Lr.No. A1/6249/90

Sub: MMDA - Planning Permission - Construction
of Residential building in Plot No.10,
at S.No.56, Ullageram Village - Approval
of - Regarding.

SITE PLAN (Scale: 1" = 16'-0")

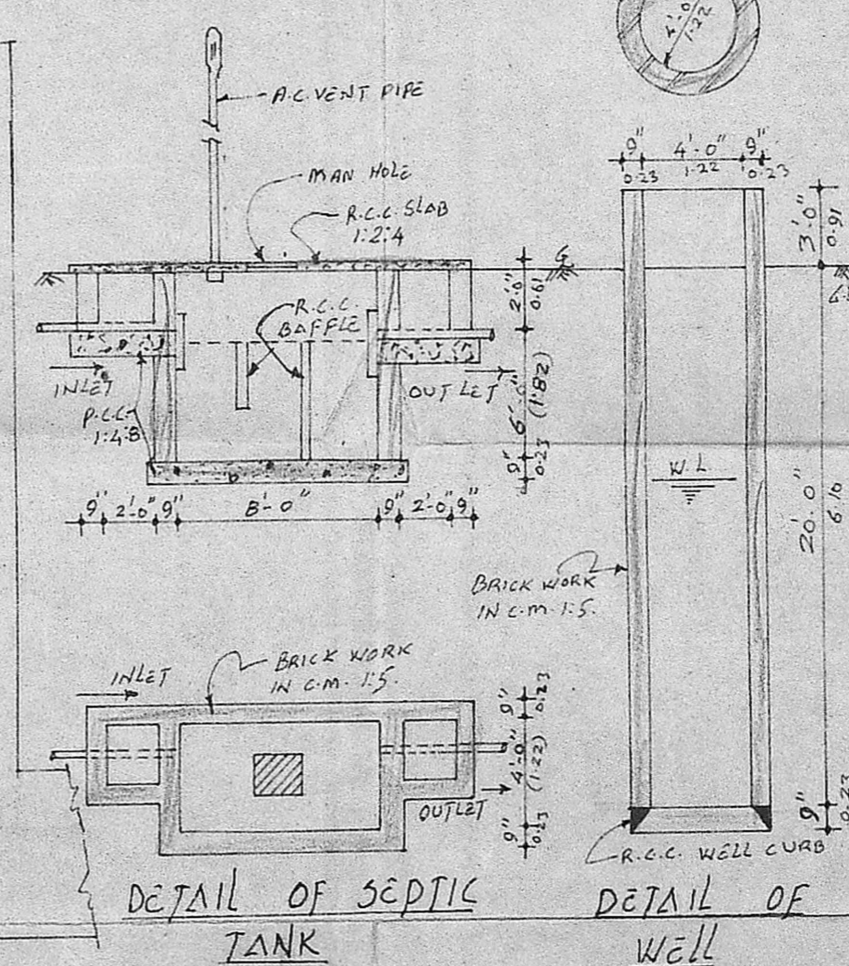
towards Regularisation charge by two separate Demand Drafts
of a Nationalised Bank in Madras City drawn in favour of the
Member-Secretary, MMDA, Madras-8 or ~~in cash~~/and pay at MMDA
office cash counter between 10.00 A.M. and 4.00 P.M. within
10 days and after remit the said amount, you are requested to
remit the duplicate receipt to Area Plans Unit. You are also
requested to submit the Affidavit for ULC in Rs.5/- stamp
paper duly attested by Notary public. Planning Permission
application will be returned unapproved if the amount are
not paid within the stipulated time. You are ~~is~~ also requested
to furnish Revised Plan showing 3m. x 3 m. as splay.
